# CITY OF ALBUQUERQUE

October 19, 2022

**Re: 98<sup>TH</sup> and Central Warehouse**  
**98<sup>th</sup> and Central**  
**Traffic Circulation Layout**  
Architect's Stamp 09-21-22 (K09-D052)

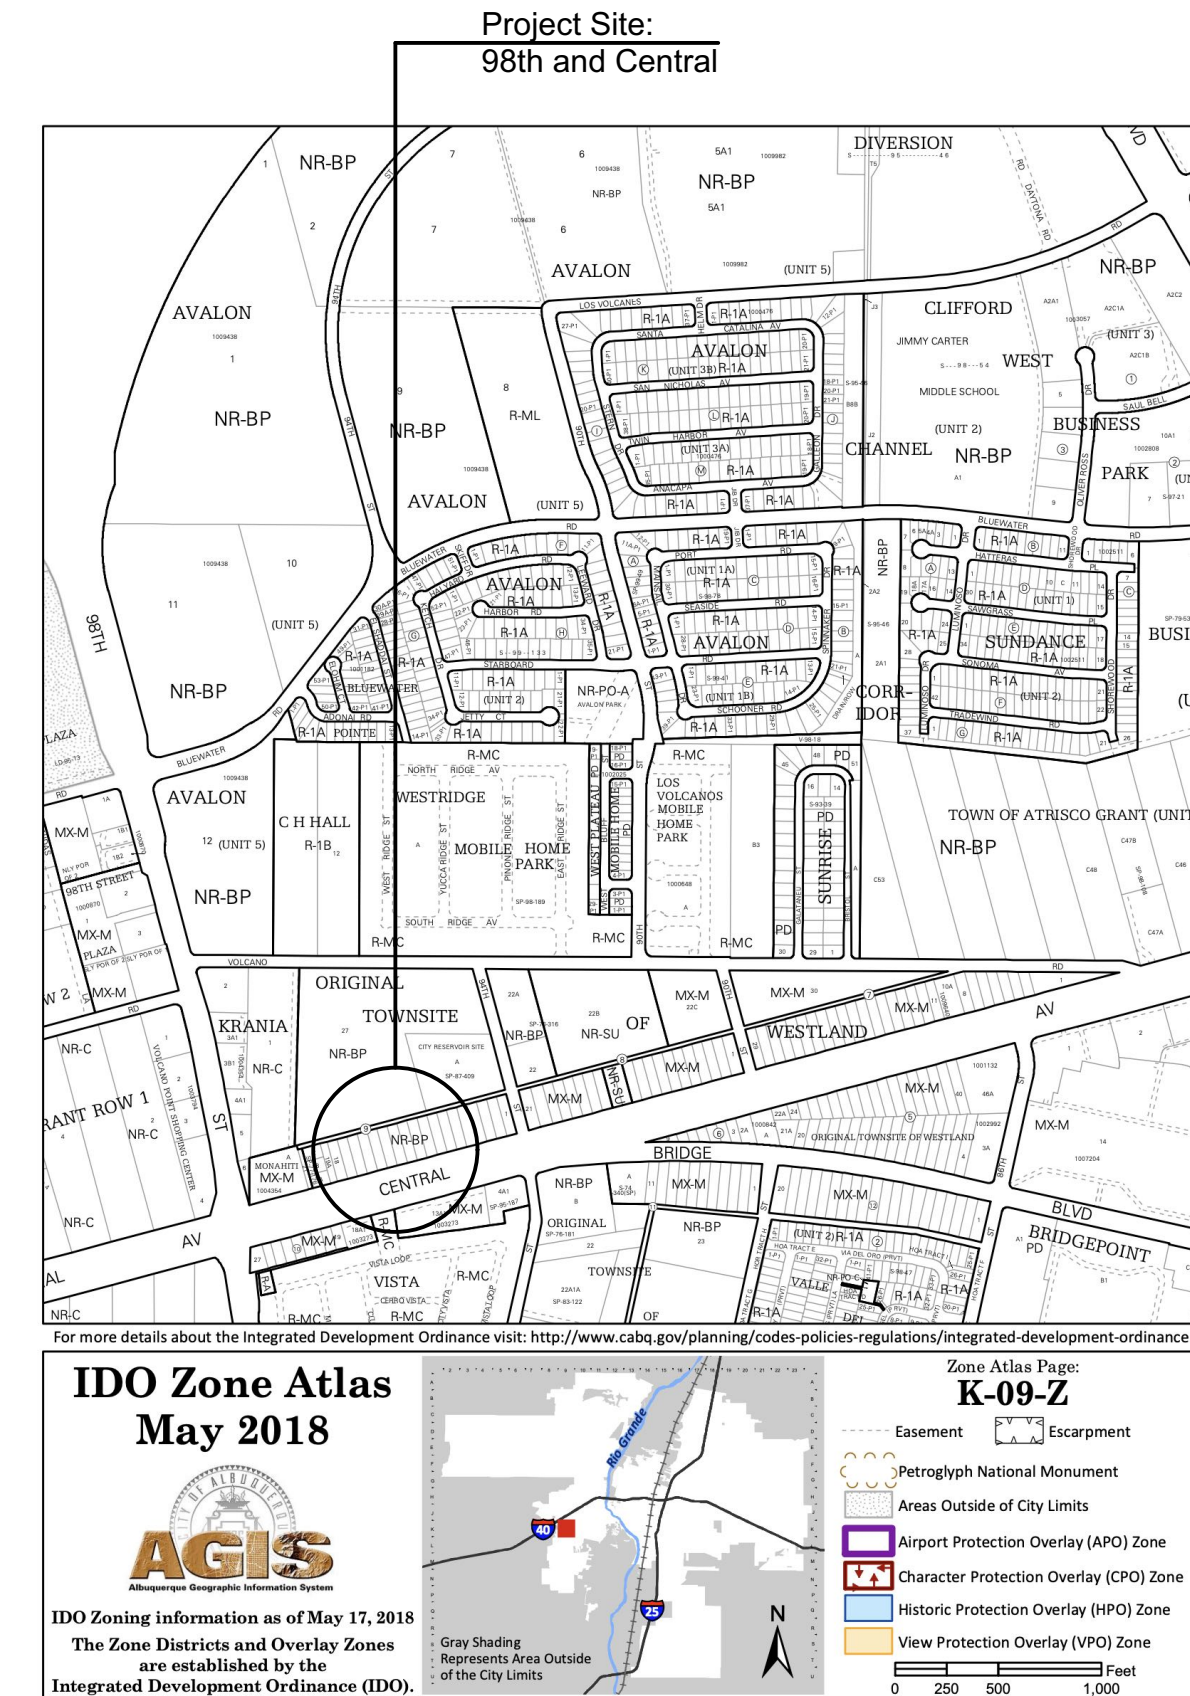
1. Curb return design need to be provided for the site accesses.
2. Please provide the width for all the proposing parking spaces.
3. Define the ADA pathway from the public sidewalk and from the ADA aisles to the building entrance, by labeling the ramps, flush, and show the building entrance on the site plan.

4. Refuse vehicle maneuvering shall be contained on-site. The refuse vehicle shall not back into the public right of way.; provide a copy of refuse approval.

5. Provide a copy of Fire Marshal approval.
6. It is not apparent what type of pavement surface is being proposed. A hard driving surface will be required as part of this proposed project for parking area and drive aisles.

7. Please specify the City Standard Drawing Number when applicable.
8. Work within the public right of way requires a work order with DRC approved plans.

9. Please add a note on the plan stating "All improvements located in the Right of Way must be included on the work order."
10. Traffic Studies: See the Traffic Impact Study (TIS) thresholds. In general, a minimum combination of 100 Vehicles entering and exiting in the peak hour warrants a Traffic Impact Study. Visit with Traffic Engineer for determination, and fill out a TIS Form that states whether one is warranted. In some cases, a trip generation may be requested for determination (Contact Matt Grush: [mgrush@cabq.gov](mailto:mgrush@cabq.gov)).
